CITY OF ALBUQUERQUE

July 9, 2013

**Re: Lot 19, Block 20, Tract 2, Unit 2, North Albuquerque Acres
11301 San Antonio Dr. NE
Grading and Drainage Plan
Engineer's Stamp dated 6-07-13 (D22/D001)**

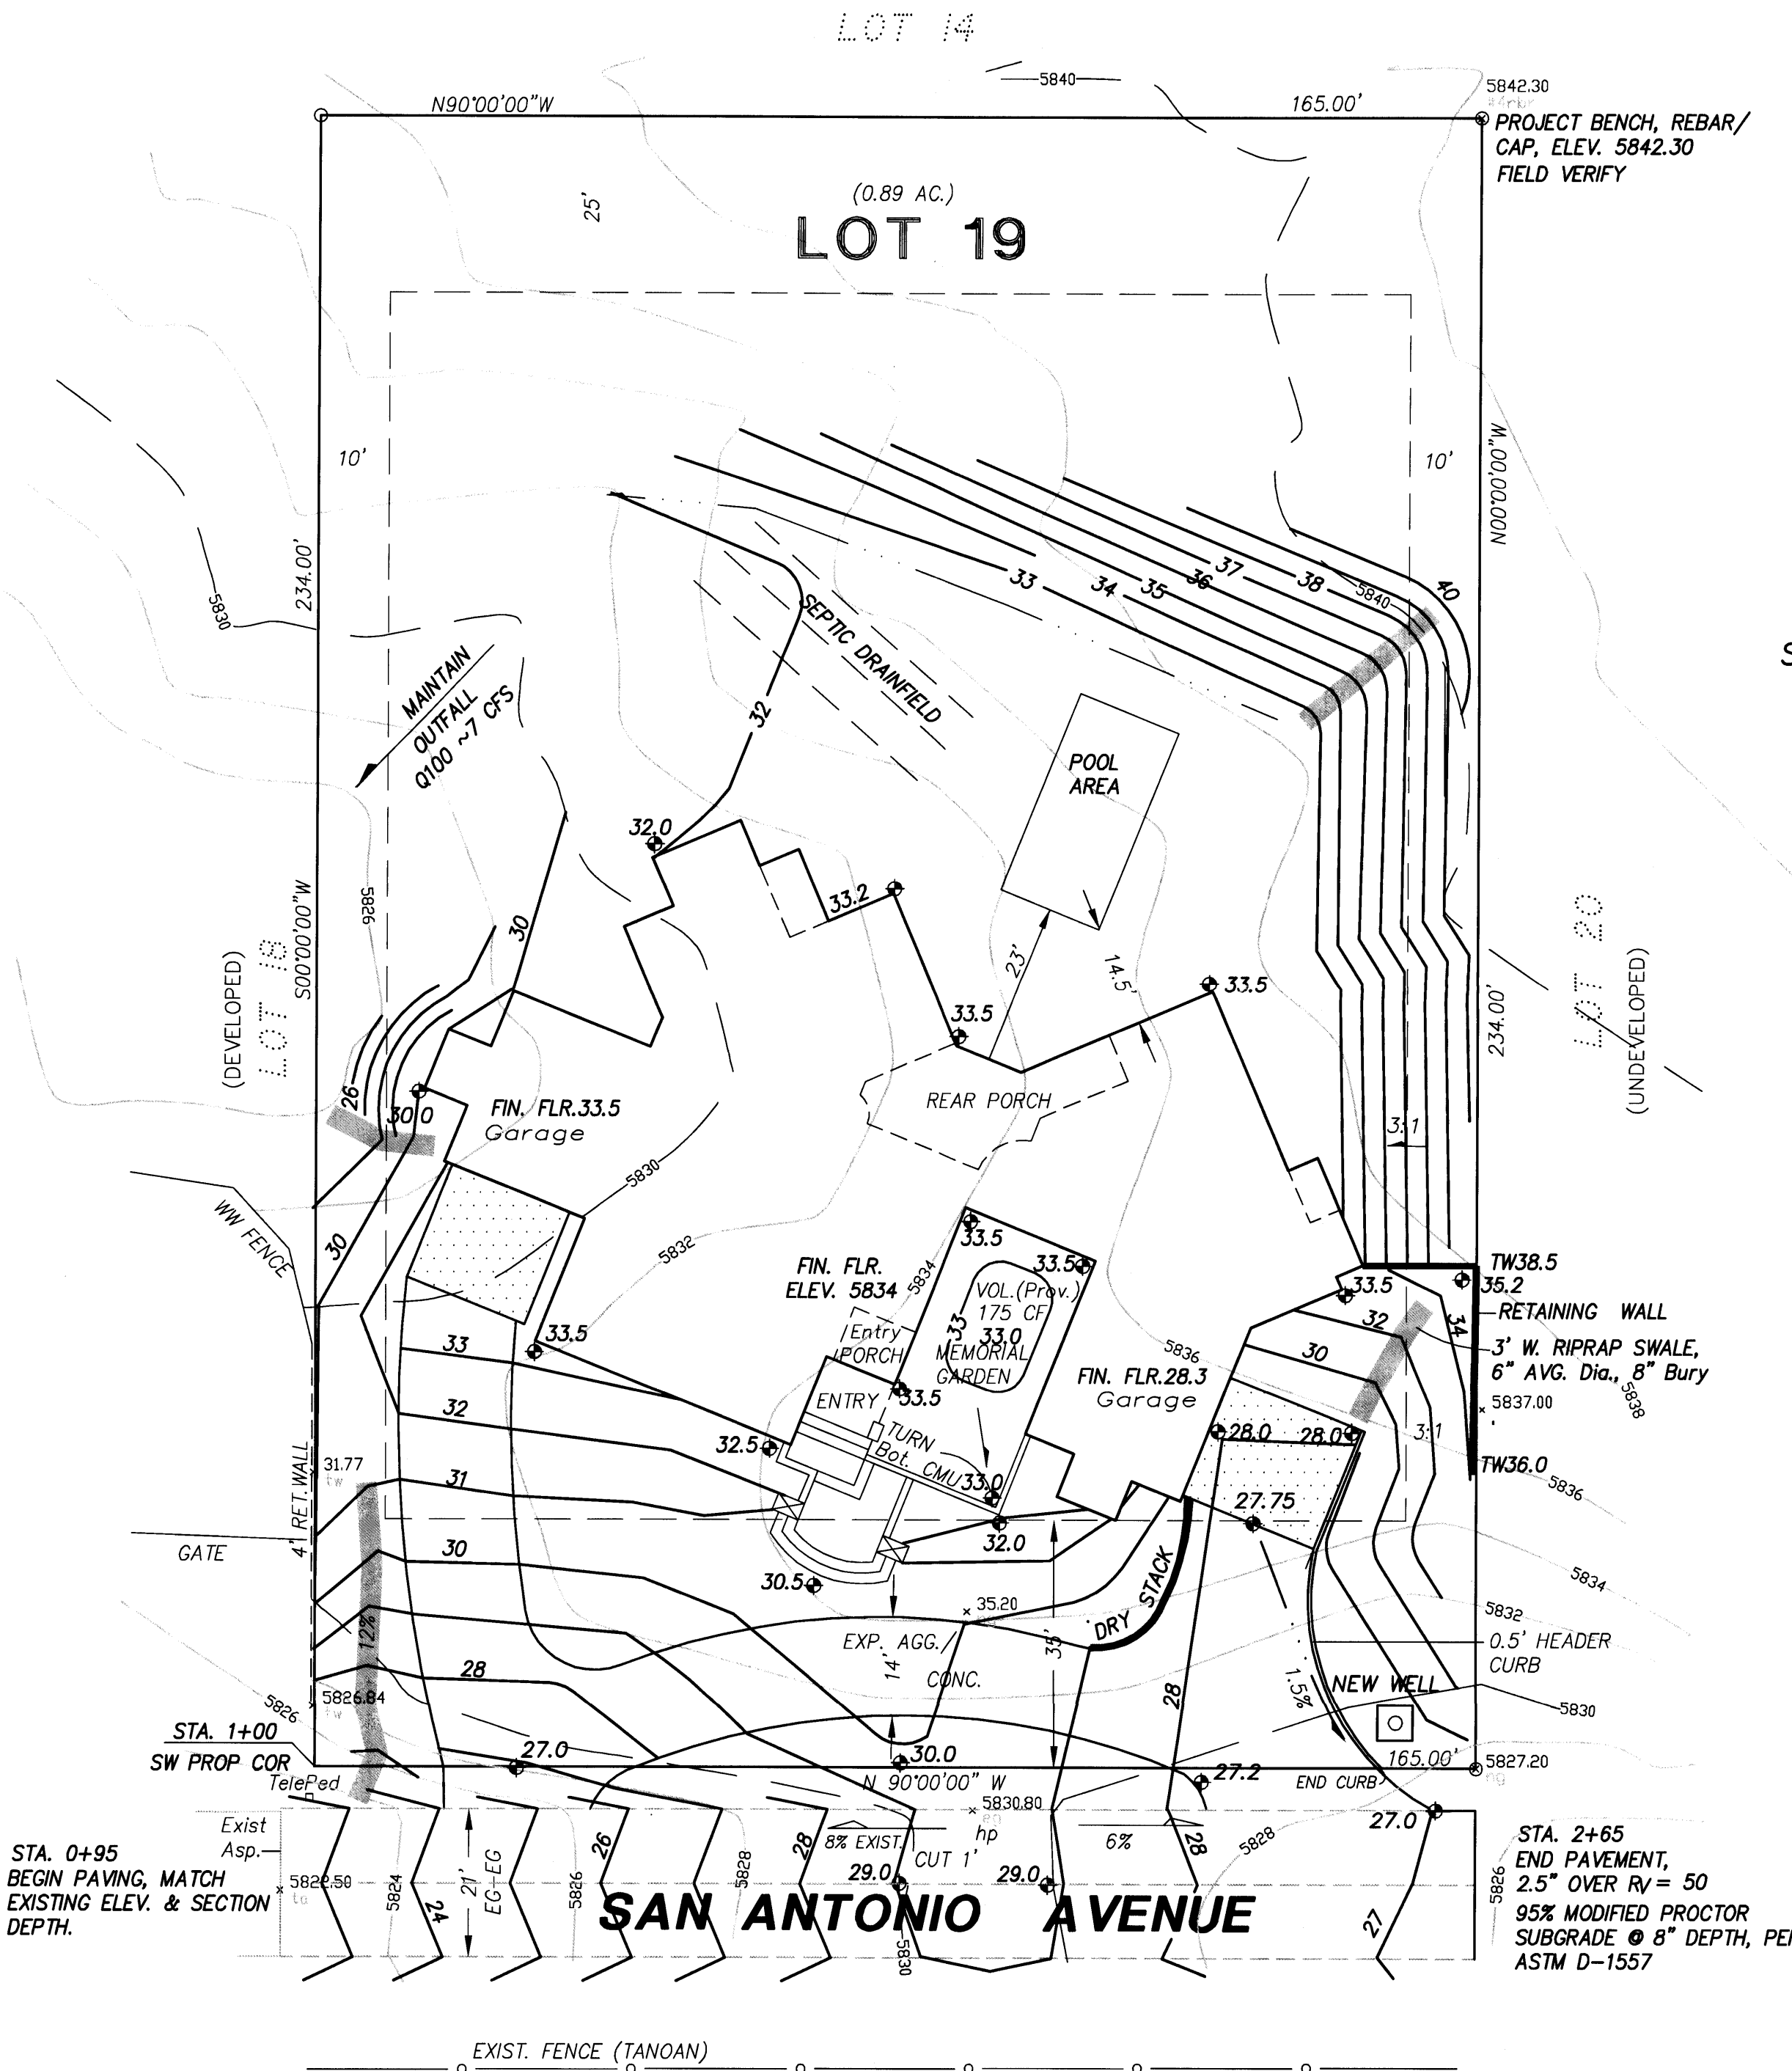
- Any work on San Antonio should be submitted and approved through Design Review Committee (DRC) and constructed through the work order process. The driveways must be constructed under the work order. Curb and gutter and sidewalk may be required.
- In most cases the entire site is disturbed as part of clearing and grubbing. Therefore, under the developed conditions Treatment A=0%.
- Please double check the "D" treatment. It appears that the D treatment is more than 27%. Clearly show all the concrete work around the pool area and other walkways.
- It is not clear how and how much runoff will drain to the proposed detention pond. Show the 4" pipe.
- A desilting pond may be required at the east end of the San Antonio Dr.

- How will the septic system be accessed? A retaining wall may have to be constructed along the westerly boundary to create the necessary access to the back.

- 7 cfs is shown to drain to Lot 18. Does this flow include the developed runoff from the back of the house? We recommend that the 7 cfs to be routed south to San Antonio. Provide more spot elevation around the pool area and the back of the house. Provide an offsite drainage basin and calculations.
- Total disturbed area included the road work will be more than one acre. Therefore, SWPPP will be required.
